**Byers Gill Solar
EN010139**

8.24 Comments on Deadline 5 Submissions

Deadline 6 - December 2024

Drawing Number  
**BGS-SR-00004**

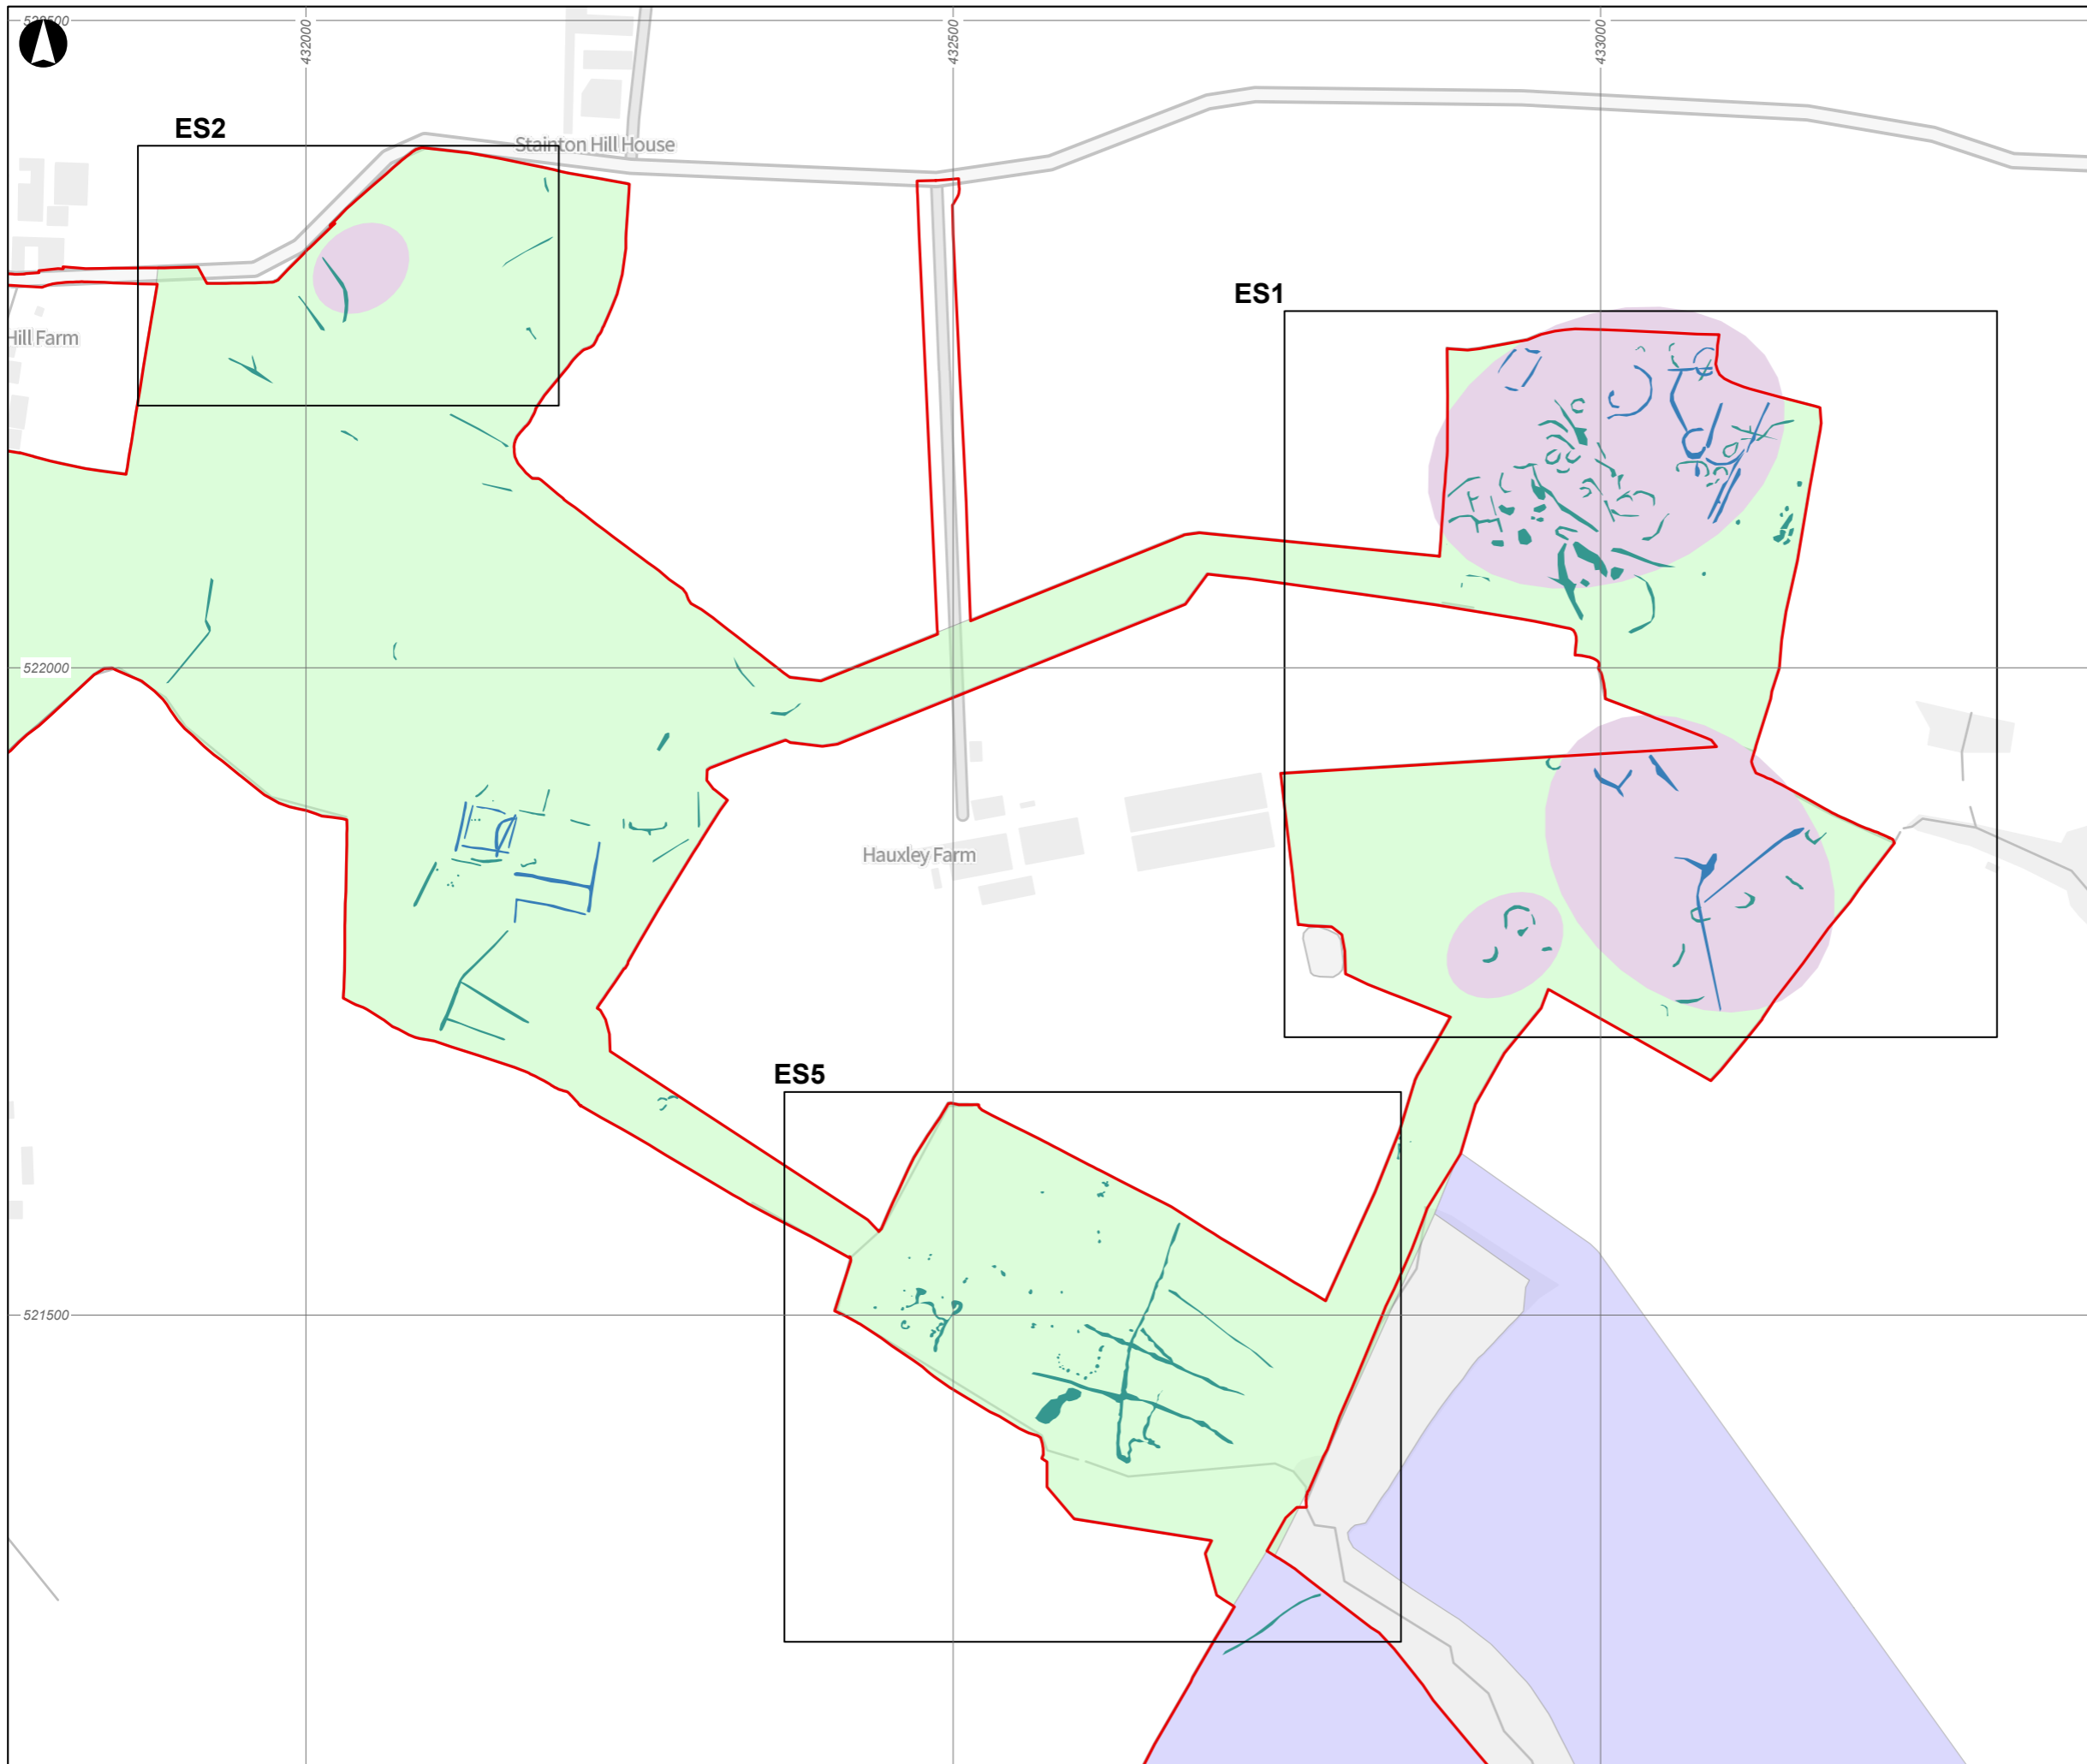
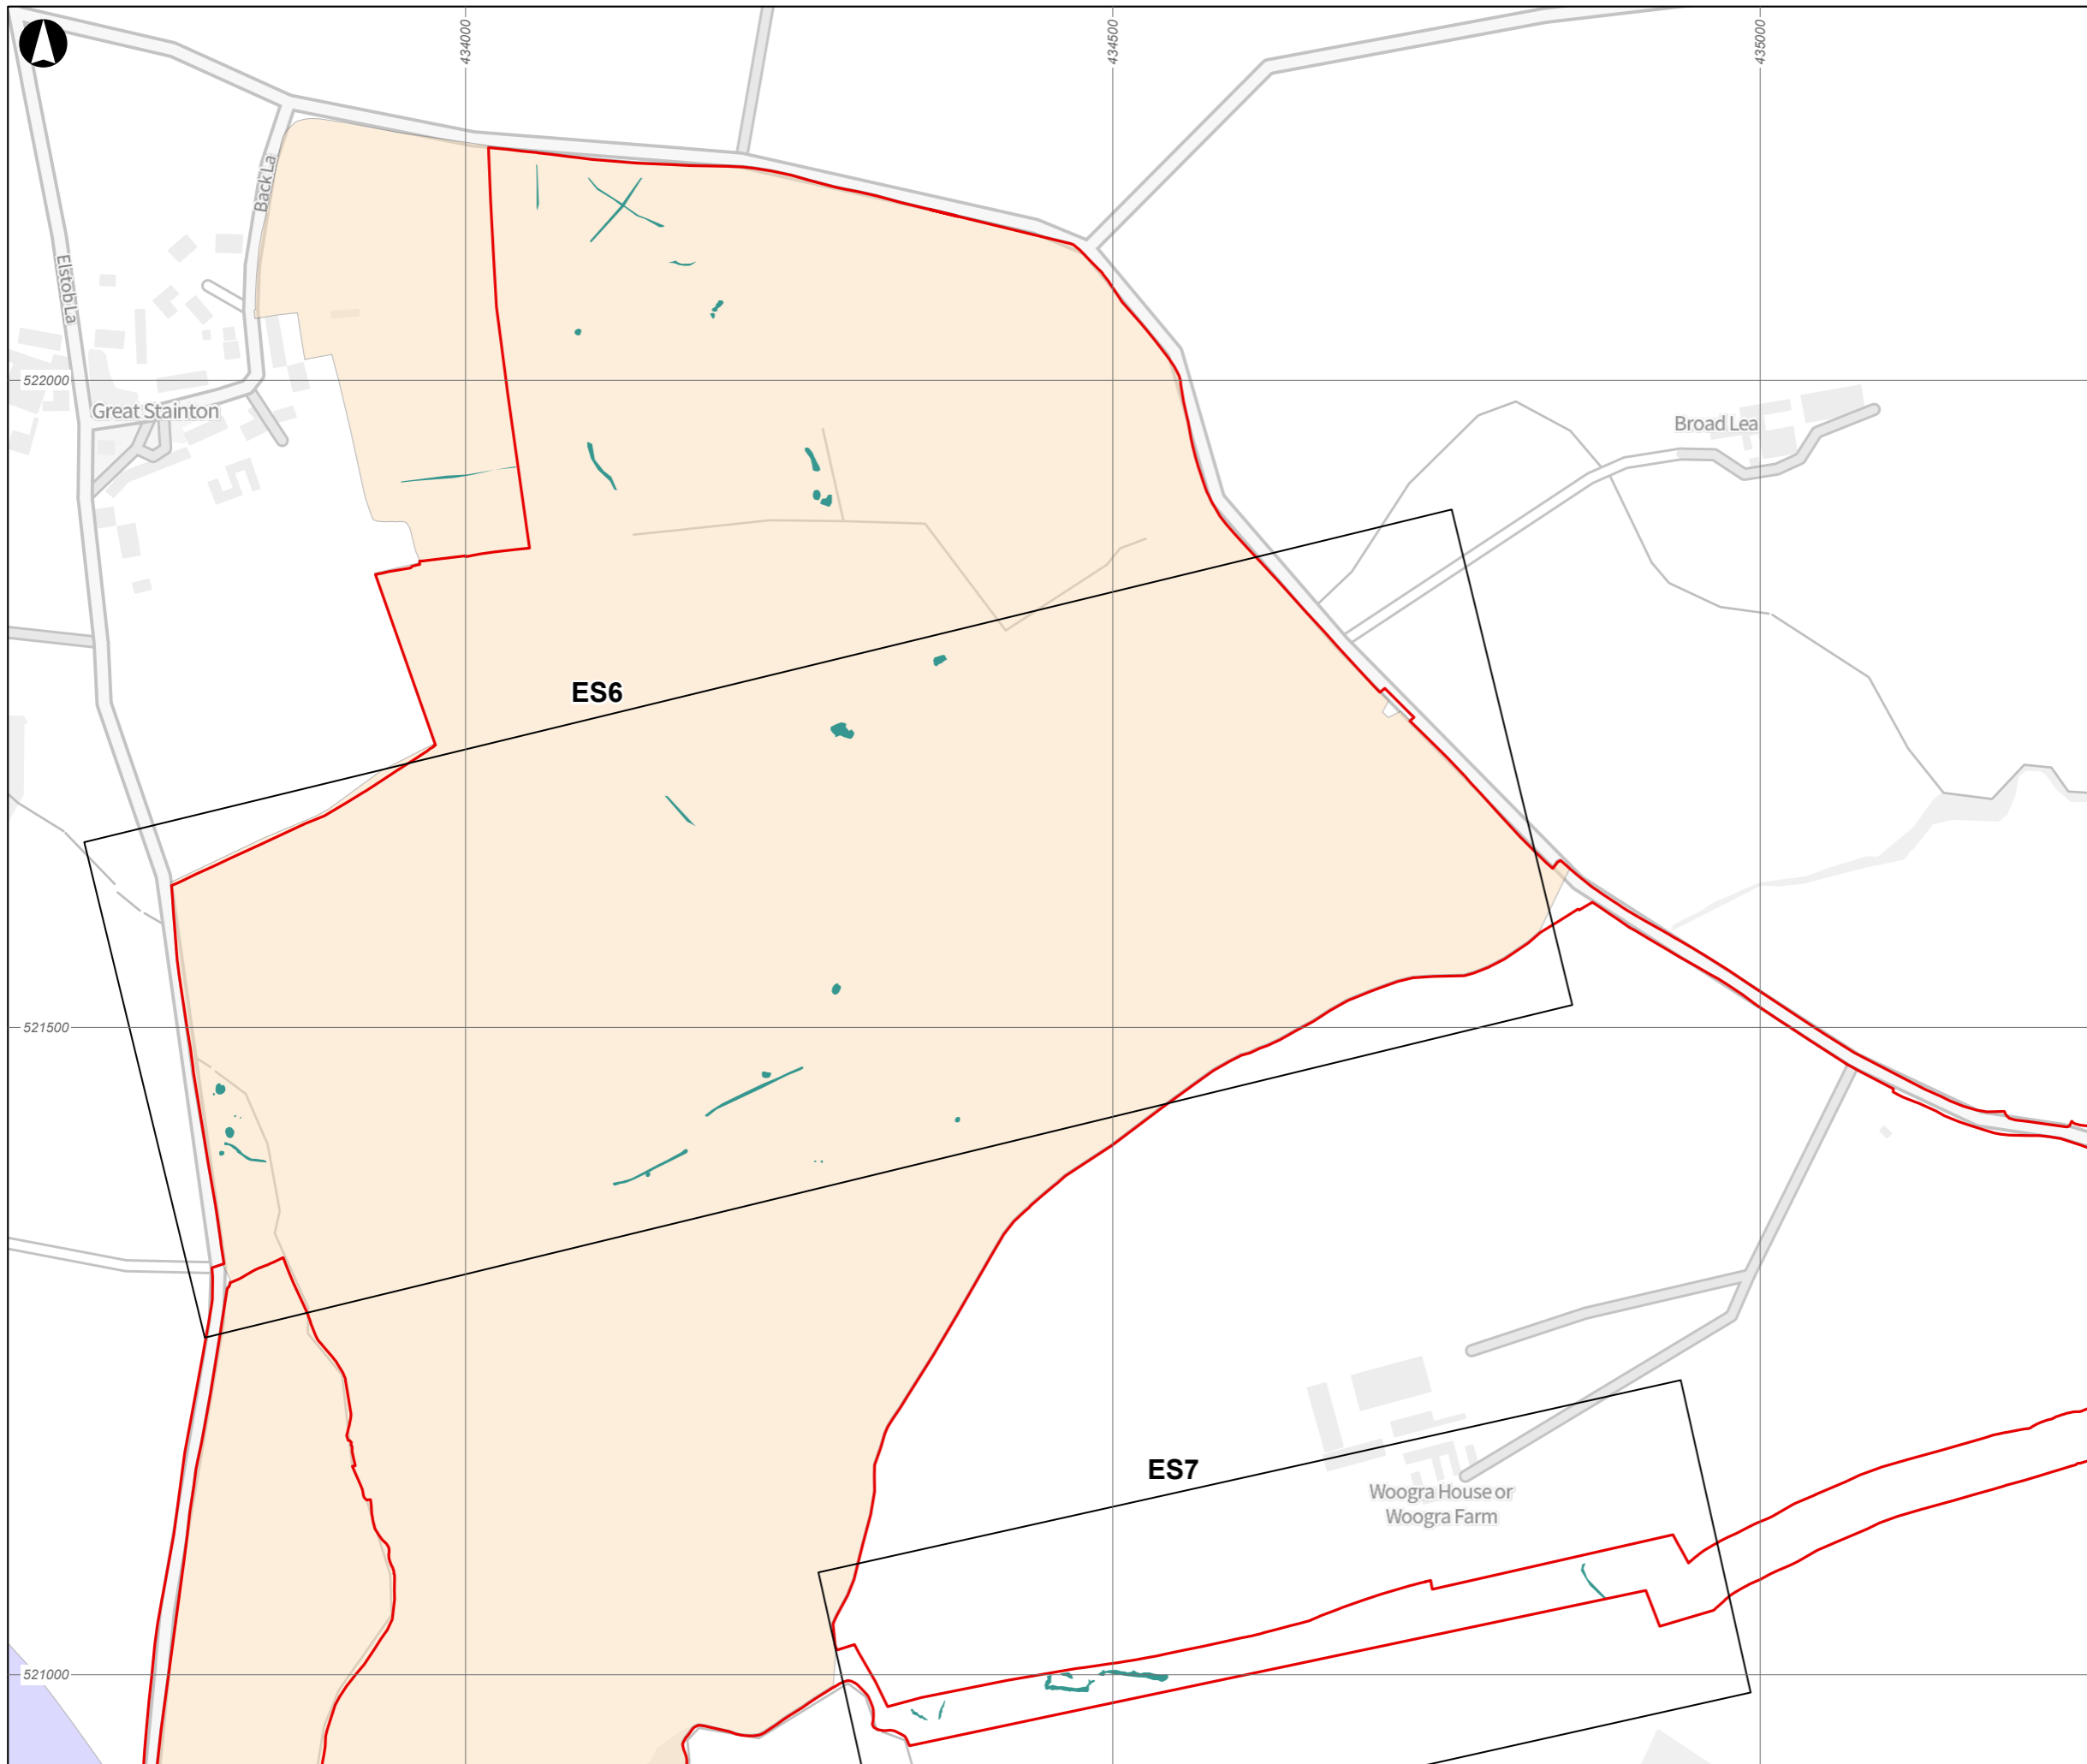
REP4-040	BVAG	<p>BVAG raised the lack of Geophysical Surveys undertaken around the Bishopton Motte and Bailey. The response by the applicant is considered inadequate and does not address why several areas were part of a Geophysical survey for archaeological assessment yet the Motte and Bailey – a Scheduled Monument and the highest grade heritage asset within the DCO area - was excluded.</p> <p>BVAG consider that Historic England's comments on settings relate to above ground assets. The Scheduled Monument which is an 11th century fortress has obvious potential underground assets. It was in fact one of a handful of Motte and Bailey's within the UK studied for potential earlier origins. The proposed construction of a major infrastructure cable immediately adjacent has the potential to harm underground assets. No reasonable explanation was given for its exclusion in the archaeological geophysical survey, and BVAG consider this</p>	<p>The Applicant considers this matter was discussed and answered sufficiently as ISH2 and refers to the summary on page 23 of REP4-010, which confirms the surveys were not undertaken at this location as it is a potential cable route and not a panel area. The provision of further archaeological investigation in this location prior to commencement is secured via Requirement 17 of the draft DCO. The Applicant notes the comments of BVAG regarding Historic England, the national statutory advisor for the historic environment.</p> <p>The Applicant and Historic England are in agreement regarding the assessment of the effects of the Proposed Development on the Scheduled Monument, as set out in the signed SoCG between the parties (Document Reference 8.4.5, Revision 2).</p>

Examination Library Reference	Interested Party	Summary	RWE Response
		<p>should be remedied before consent is granted. A post consent precautionary approach as proposed by the applicant at the Hearing is inadequate for such a high grade asset of this nature.</p> <p>BVAG are undertaking further research into this site and will be reporting in due course.</p>
